Planning Act 2008 (as amended)
Oxfordshire Railfreight Limited

Application pursuant to section 37 for a Development Consent Order in respect of the construction of a Strategic Rail Freight Interchange, highways and associated development, referred to as The Oxfordshire Strategic Rail Freight Interchange and Highways Order 202X

Applicant's Response to S51 Advice

OxSRFI – Applicant’s Response to PINS S51 Advice on Acceptance

PHASE 1 INTERMODAL TERMINAL - ILLUSTRATIVE LAYOUT PLAN

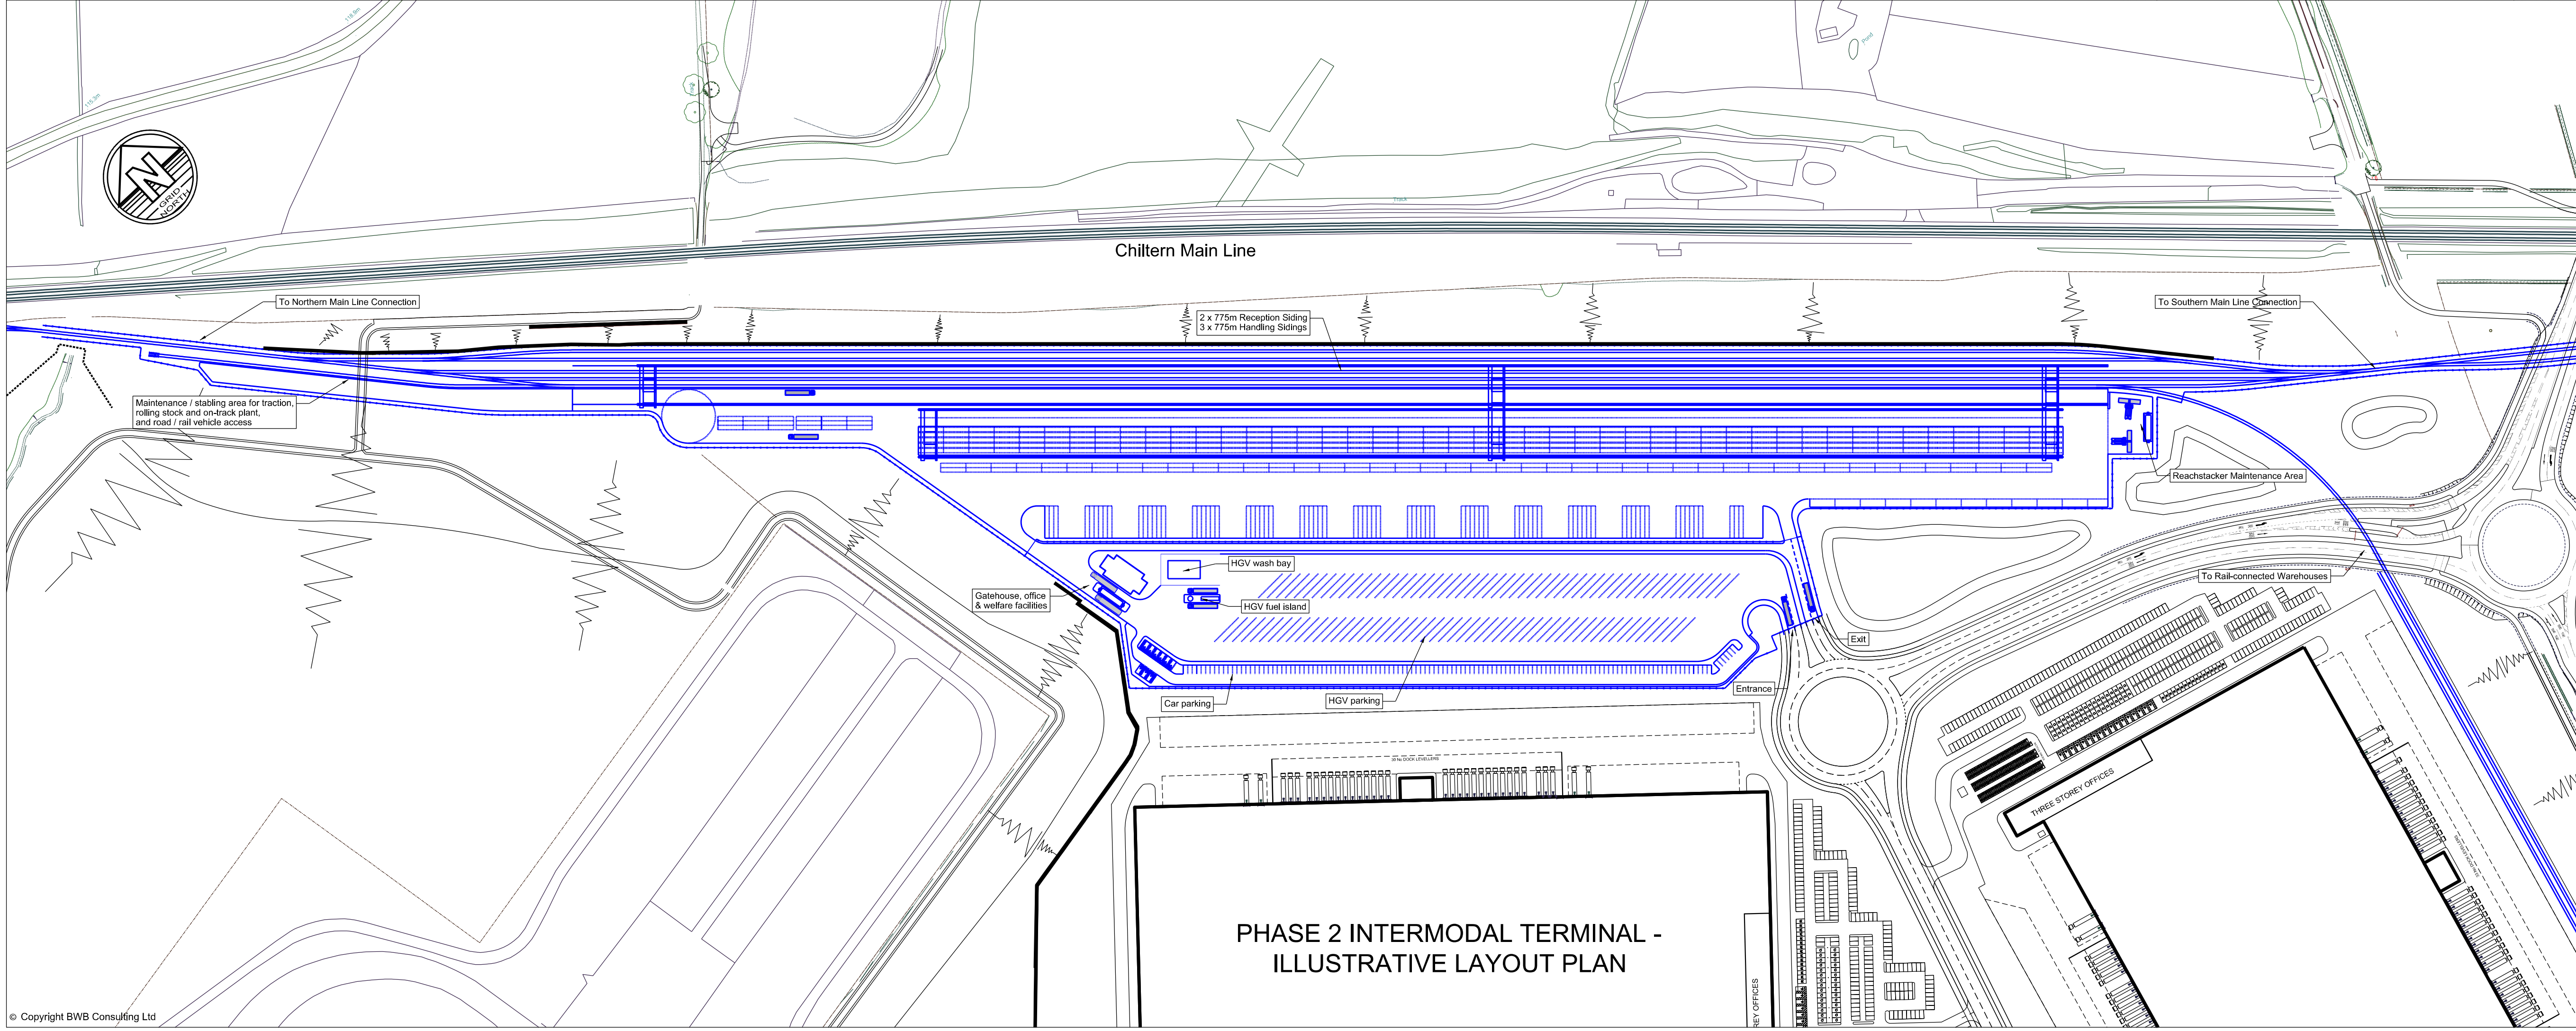
b.	<p>Document 2.11D Illustrative Rail Terminal Plan does not contain any notes or legend. It also shows two scales in the bottom right hand corner ("1:2000 (P)" and "1:400 (XS)) with no explanation of what they relate to.</p>	<p>Document 2.11D has been amended to:</p> <ul style="list-style-type: none"> • add notes and a legend • retain reference to scale 1:2000 only • remove reference to an internal file path at the bottom of the plan <p>The plan is now revision P03. This will need to be updated in Schedule 16 (Certified Documents) of the DCO. The Applicant will make this change when a revised DCO is submitted during the Examination.</p>

2.11D	Illustrative Rail Terminal Plan	<p>Amended as follows:</p> <ul style="list-style-type: none"> • Add notes and a legend; • Retain reference to scale 1:2000 only; • Remove reference to an internal file path at the bottom of the plan.
